DRB CASE NO/PROJECT NO: 1006749

Project Name: FOUR HILLS VILLAGE AND 14TH INSTALLMENTS UNIT 2ND & 14TH

RE: Lot 24, Block 13, Four Hills Village Addition

INDEXING INFORMATION FOR COUNTY	DRAWN: E W K	SCALE: 1" = 40'	FILE NO. SP-9-01-2008
OWNER: MOROSIN LOCATION: SEC. 35 T.10 N., R.4 E., N.M.P.M. FOUR HILLS VILLAGE 14th INSTALLMENT	CHECKED: T D J	DRAWING NO. SP90108.DWG	SHEET 1 OF 2
		22 SEP 08

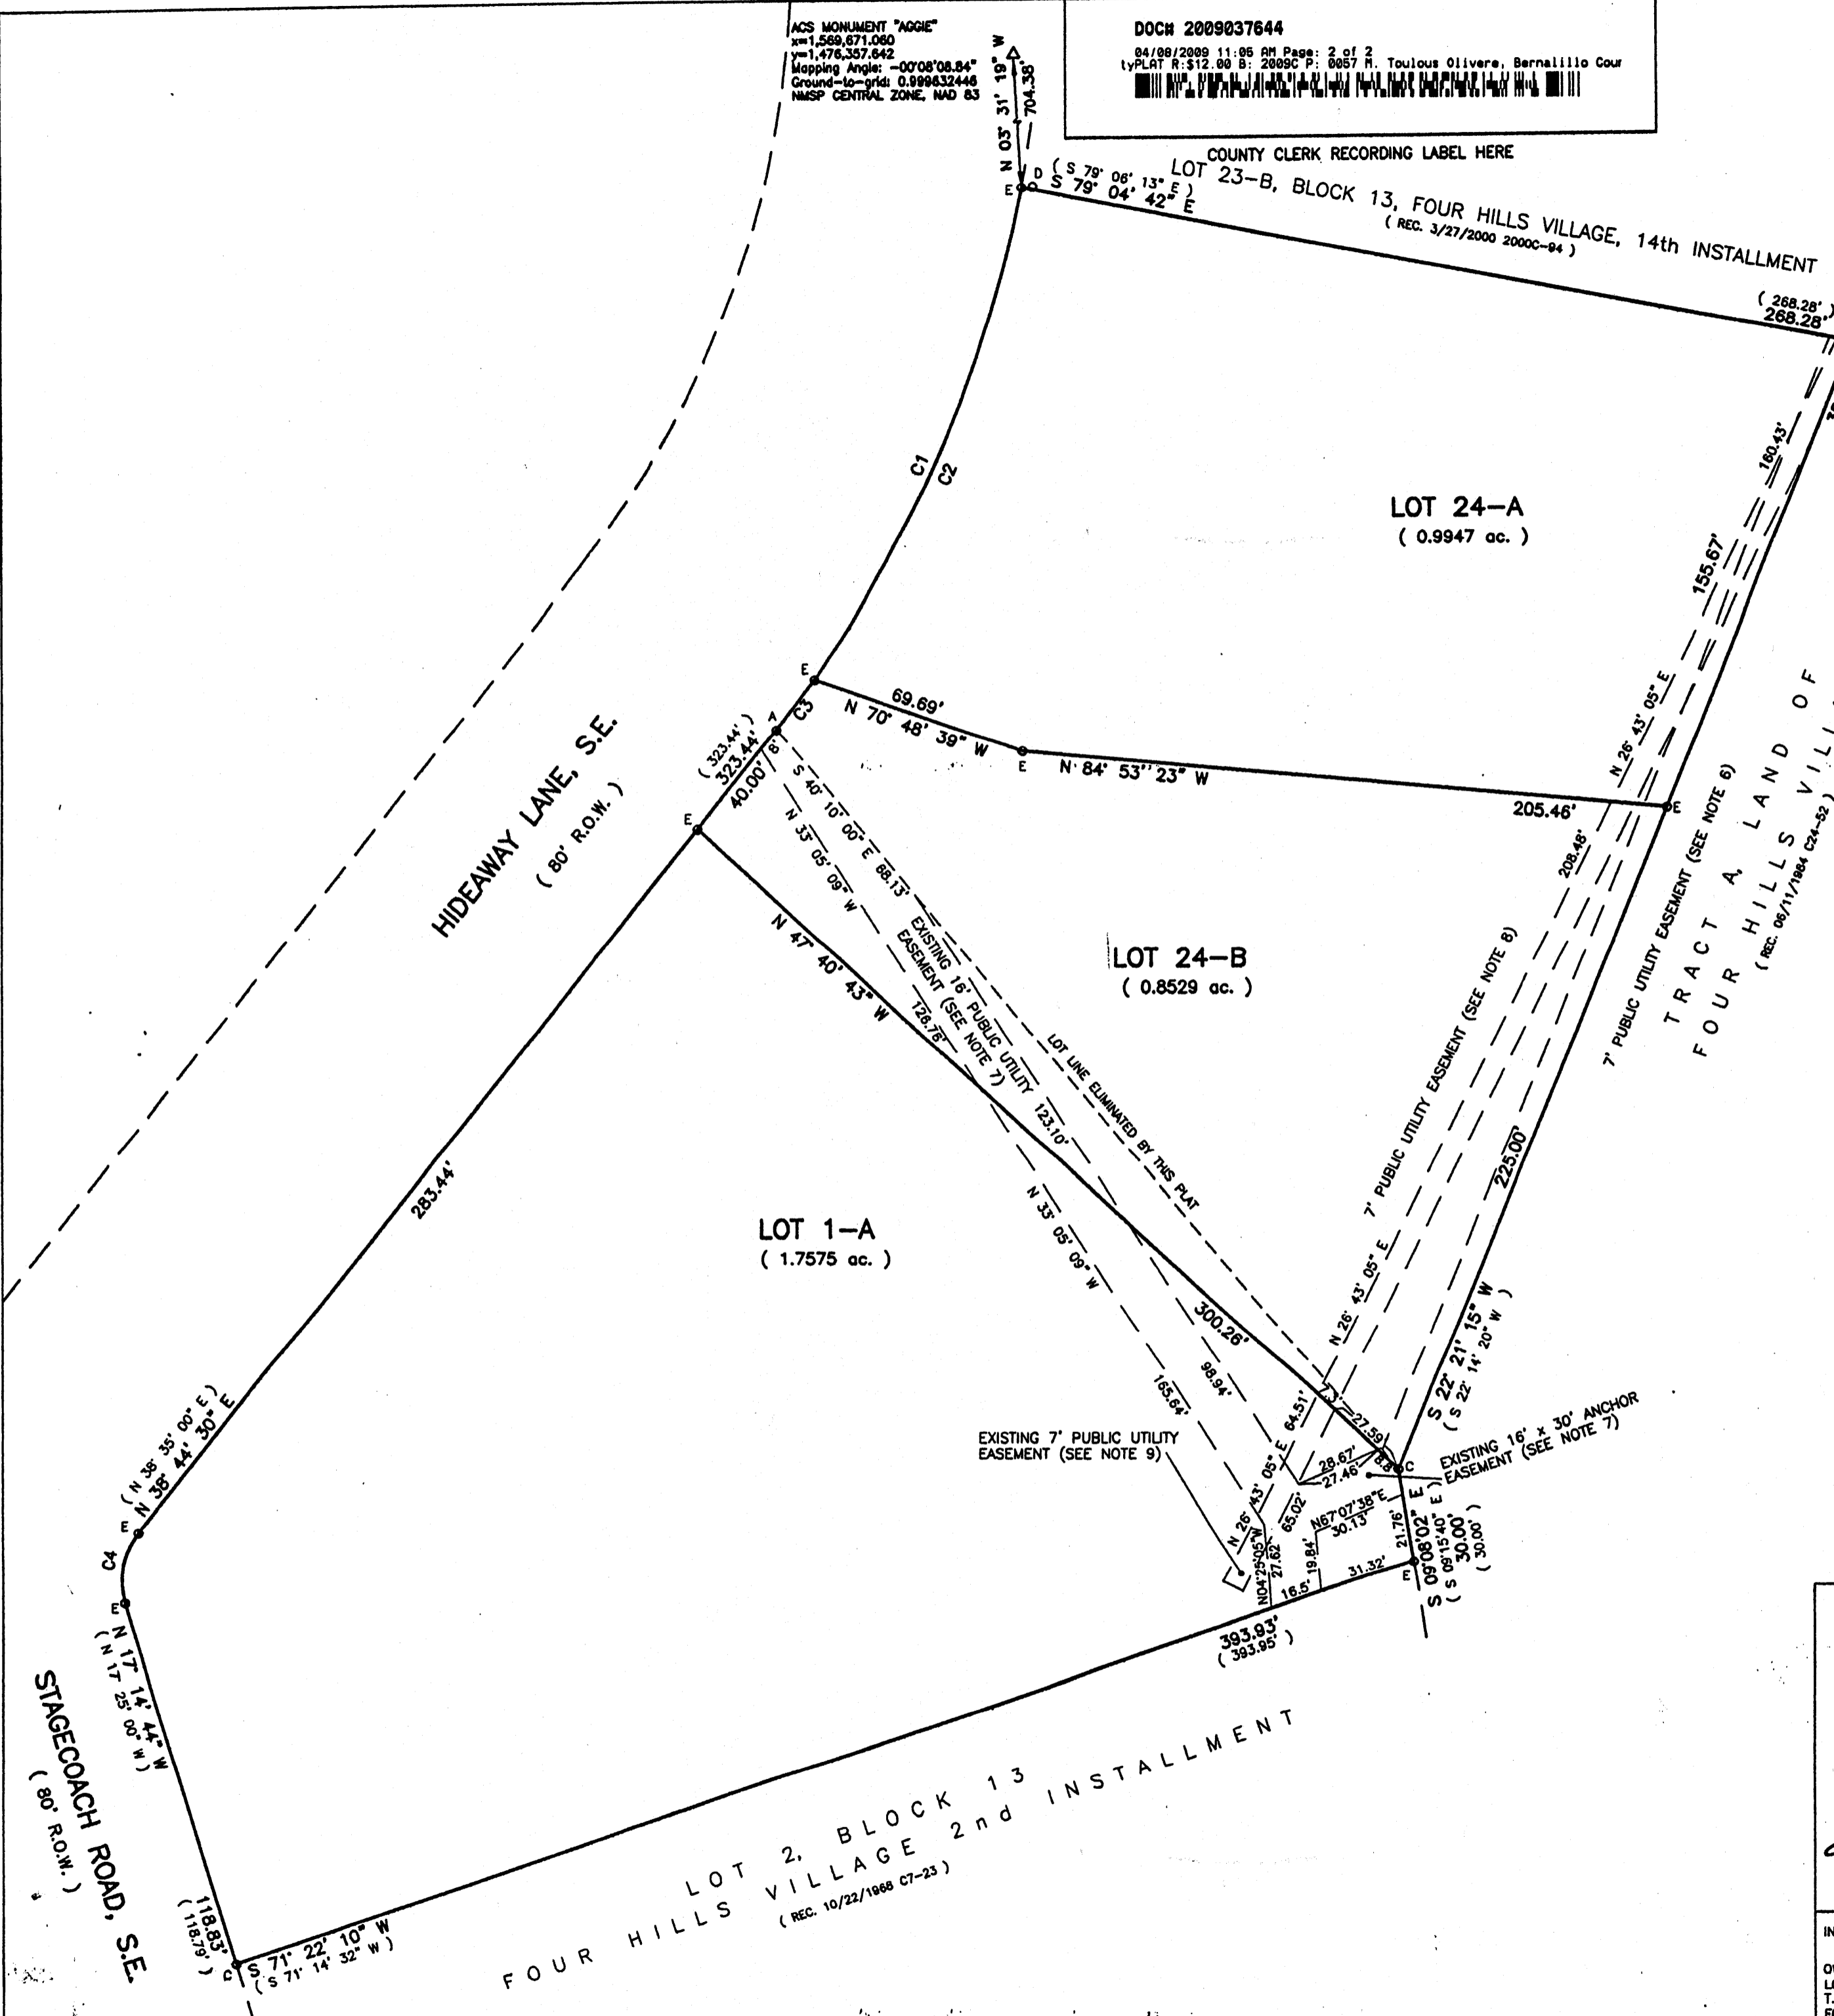
Need cross-lot drainage easement.

The 'narrow neck entrance' to the proposed new lot would need to be a private access, drainage, water & sewer easement overlaid on the 'front' lot.

- 1) Standard infrastructure per the DPM is required.
- 2) What is the distance from face of curb to the property line?
- 3) Are the sidewalks in place?
- 4) The access to the rear lot will need to be 15' minimum.

A cross lot drainage easement will be required.

PLAT EXHIBIT OF
LOTS 24-A & 24-B
BLOCK 13
FOUR HILLS VILLAGE
FOURTEENTH INSTALLMENT
 A REPLAT OF LOT 24, BLOCK 13, FOUR HILLS VILLAGE FOURTEENTH INSTALLMENT
 WITHIN SECTION 35, T.10N., R.4E., N.M.P.M.
 ALBUQUERQUE, BERNALILLO COUNTY, NEW MEXICO
 SEPTEMBER 2008

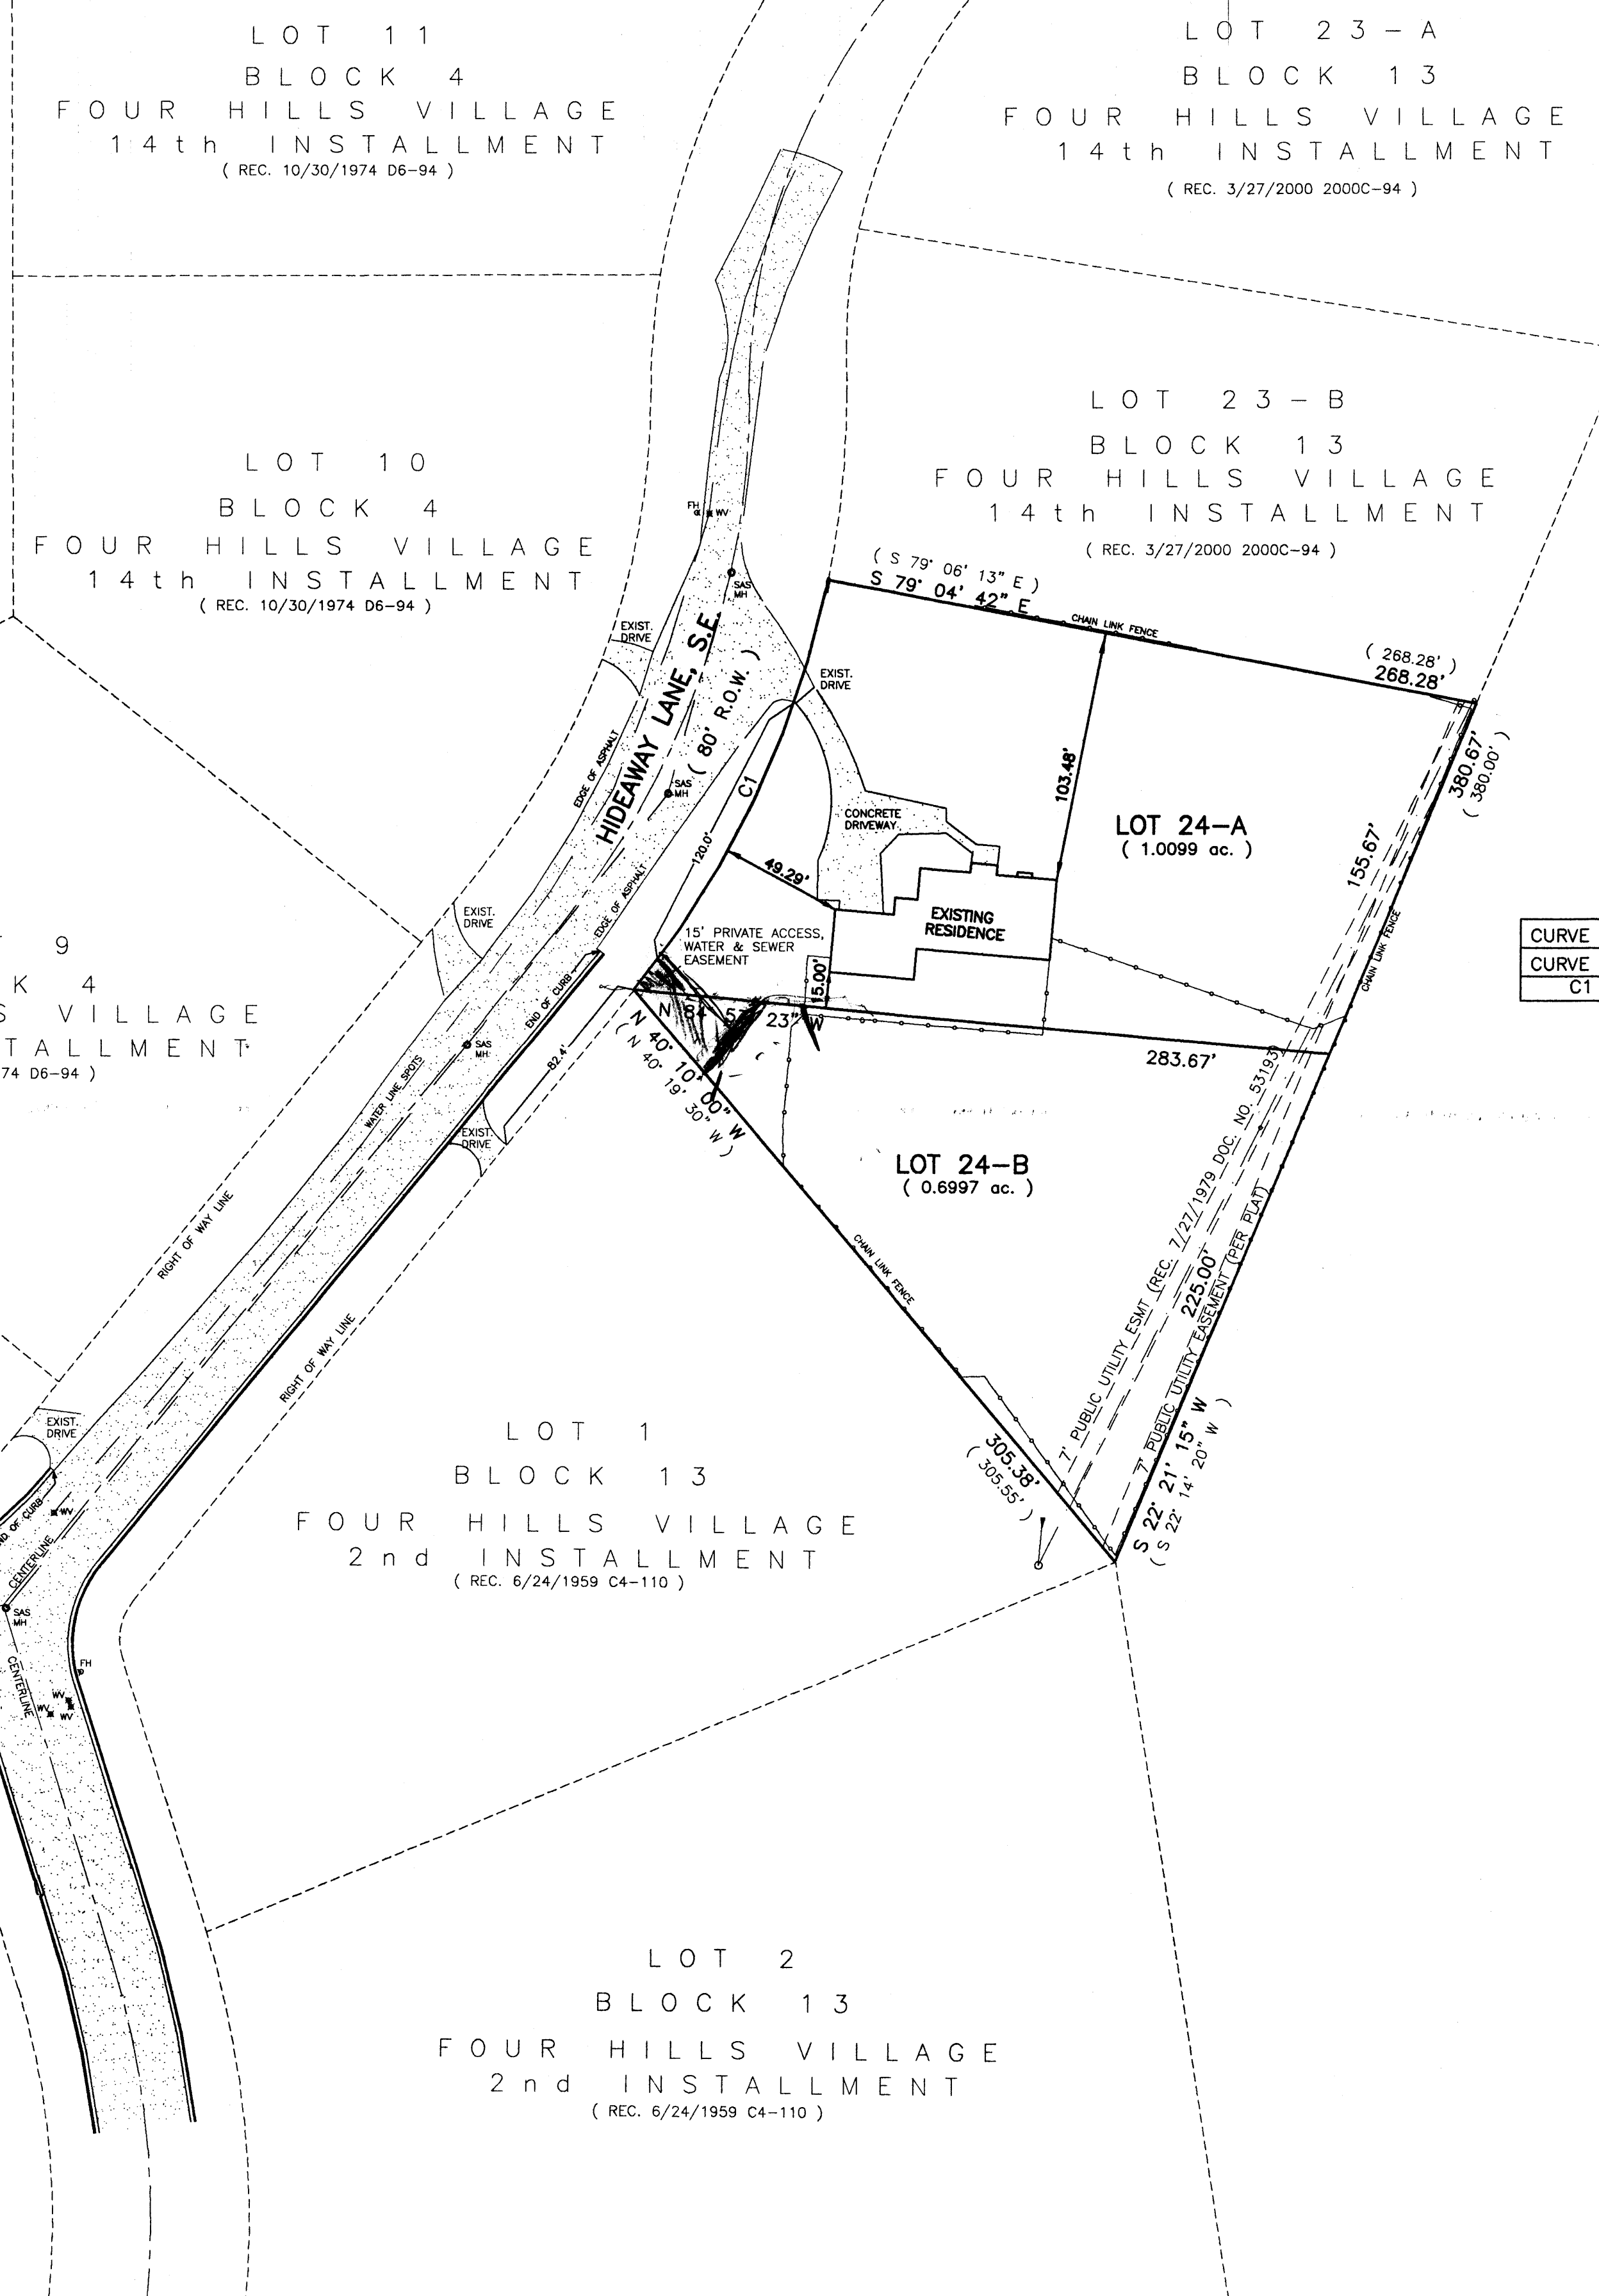
A Sidewalk Variance request must accompany a plat application; based on the low density of and lack of sidewalks in the area, the Planning Department would not object to such a variance.

Waiver of curb and gutter would require a Subdivision Design Variance (which also must accompany a plat application). Planning would not support such a variance.

The proposed plat still does not meet the minimum 60 foot lot width requirement, which is measured 50 feet back from the edge of the access easement.
